## Stage 1 Road Safety Audit: Designer's Response

Scheme: Sefter Farm, Pagham Road, Pagham – Existing Highway Arrangements

Date Audit Completed: 7 September 2016

Date Designer's Response Completed: 21 February 2017

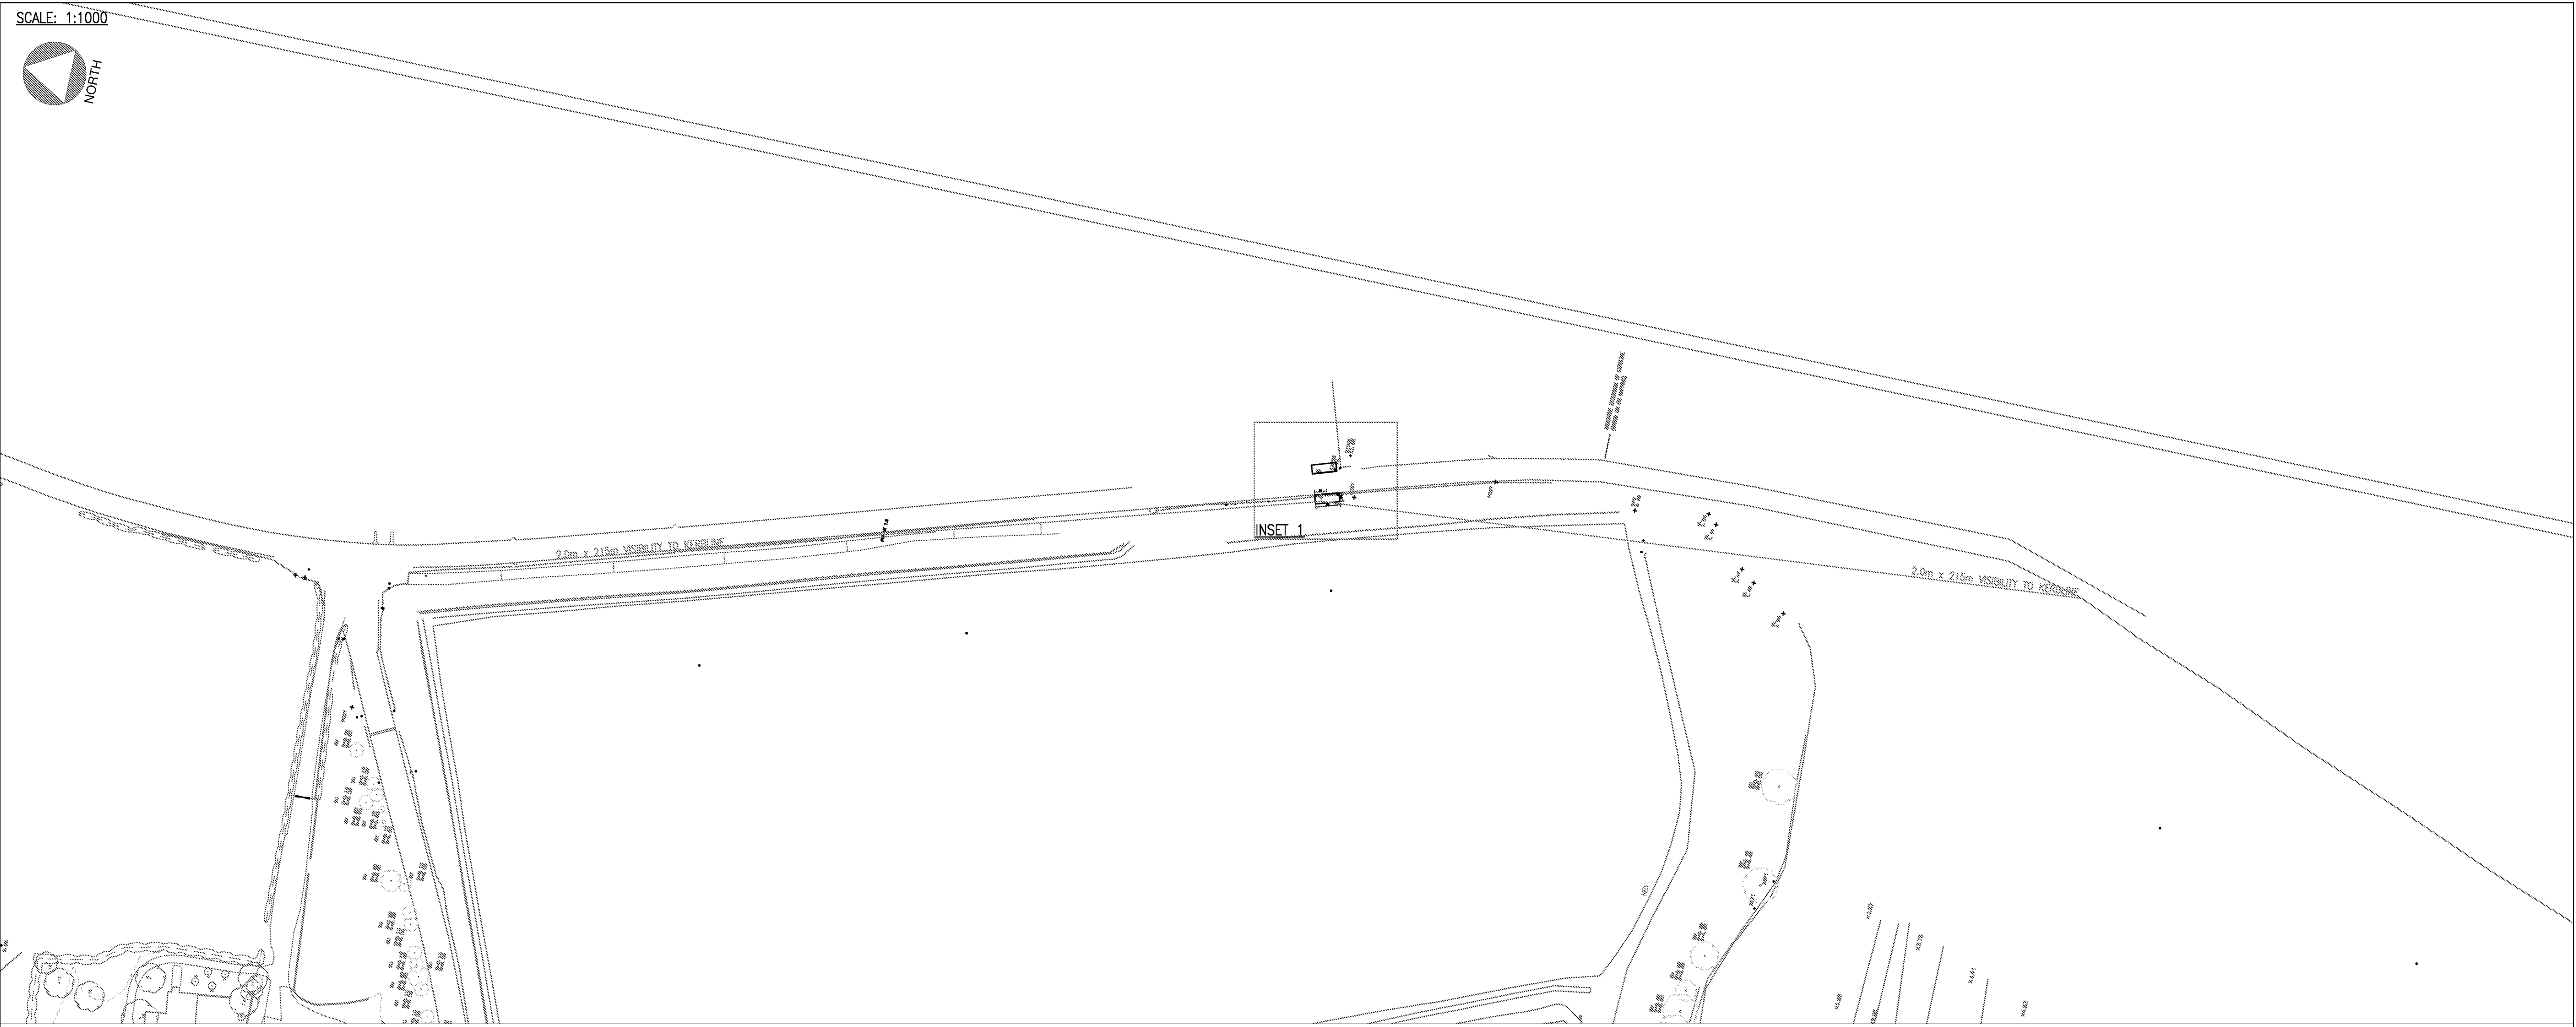
The hedge row on the eastern verge to the north of the Barfoots access restricts the 2.4m x 215m visibility splay for traffic waiting to turn right from Barfoots. The same hedge row also reduces the forward visibility for southbound traffic on Pagham Road approaching any queuing traffic waiting to turn right in to Barfoots increasing risk of tail-end shunts.

The offending vegetation to the north of Barfoots access should be trimmed back ensuring this is carried out at regular intervals to maintain visibility.

| Problem no. in safety audit report | Problem accepted (yes/no) | Recommended measure accepted (yes/no) | Alternative measure (detail description) (Designer's Response)                                                 |
|------------------------------------|---------------------------|---------------------------------------|----------------------------------------------------------------------------------------------------------------|
| 3.1                                | Yes                       | Yes                                   | Vegetation should be trimmed back by 500mm to ensure visibility in accordance with drawing number 020.0259.005 |

INSET 1: BUS STOP & PEDESTRIAN CROSSING POINT

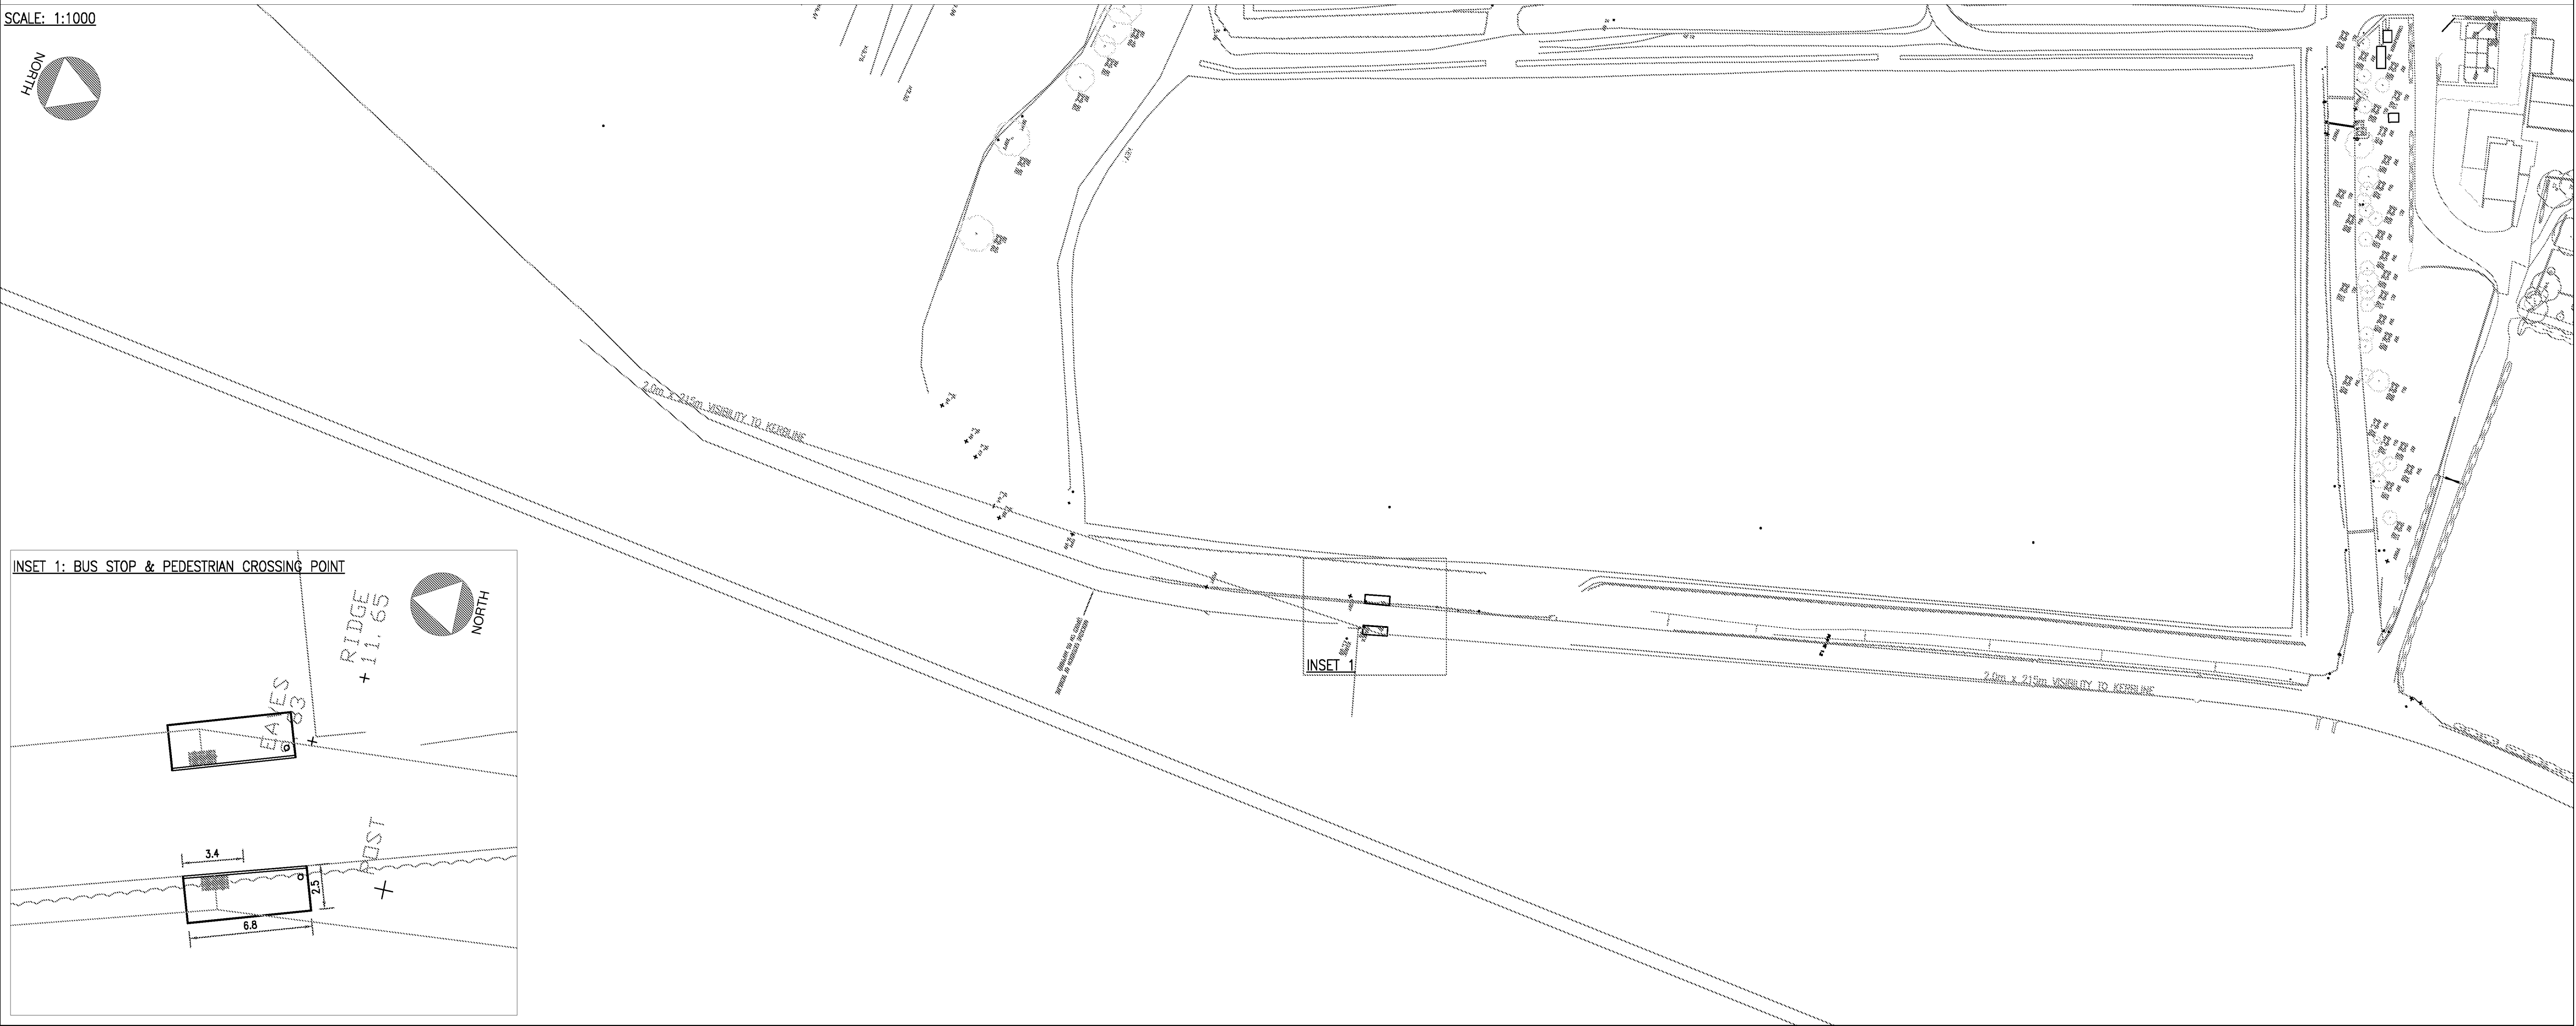
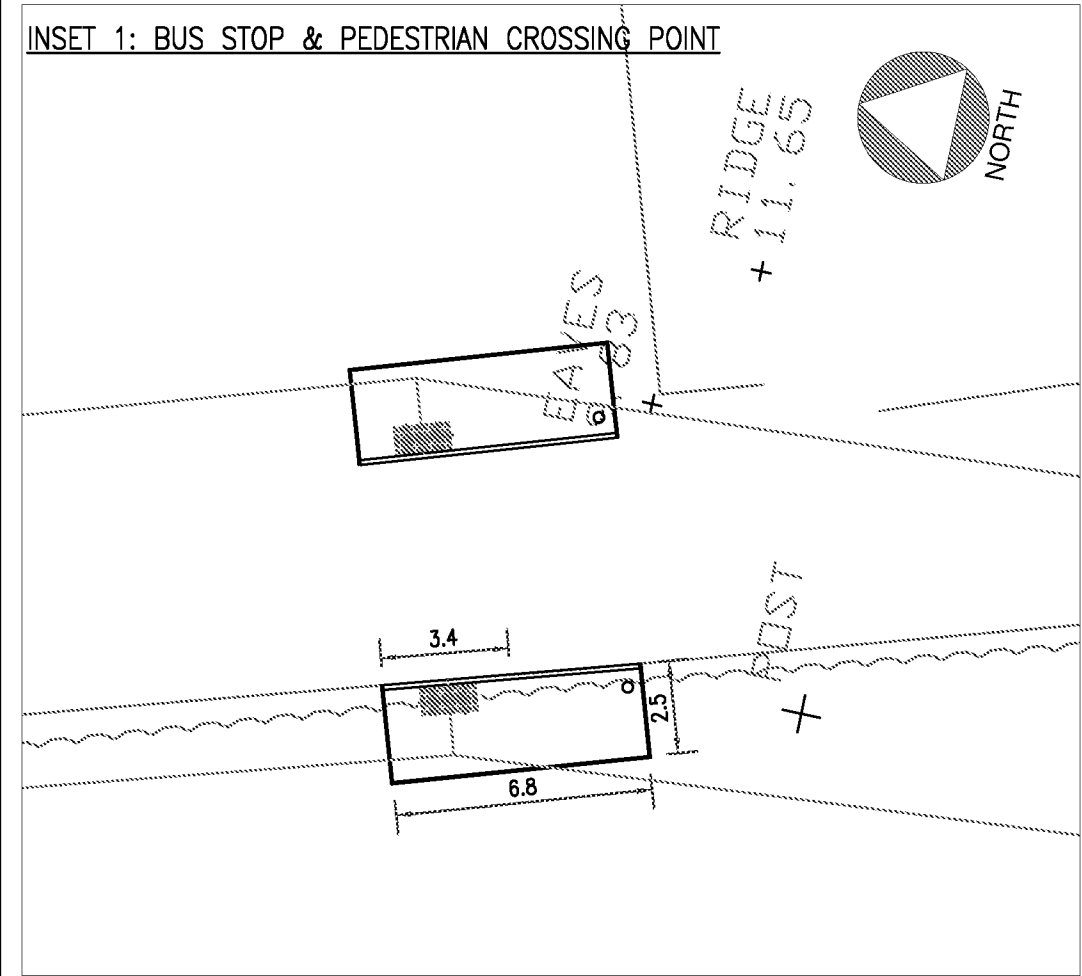
The visibility for pedestrians leaving the private footpath to cross Pagham Road is severely restricted by the hedges either side of the cutting. This also results in approaching traffic being unaware of pedestrians waiting to cross and could lead to pedestrians stepping out in front of oncoming traffic.

The hedge row to the south of the pedestrian cutting in the vicinity of Sefter Road should be removed and set back from the cutting to the existing sign opposite the junction. South of this point the hedge row should be trimmed back as should the hedge north of the cutting ensuring this is carried out at regular intervals to maintain visibility.

| Problem no. in safety audit report | Problem accepted (yes/no) | Recommended measure accepted (yes/no) | Alternative measure (detail description) (Designer's Response)                                                 |
|------------------------------------|---------------------------|---------------------------------------|----------------------------------------------------------------------------------------------------------------|
| 3.2                                | Yes                       | Yes                                   | In accordance with drawing number 020.0259.004.                                                                |
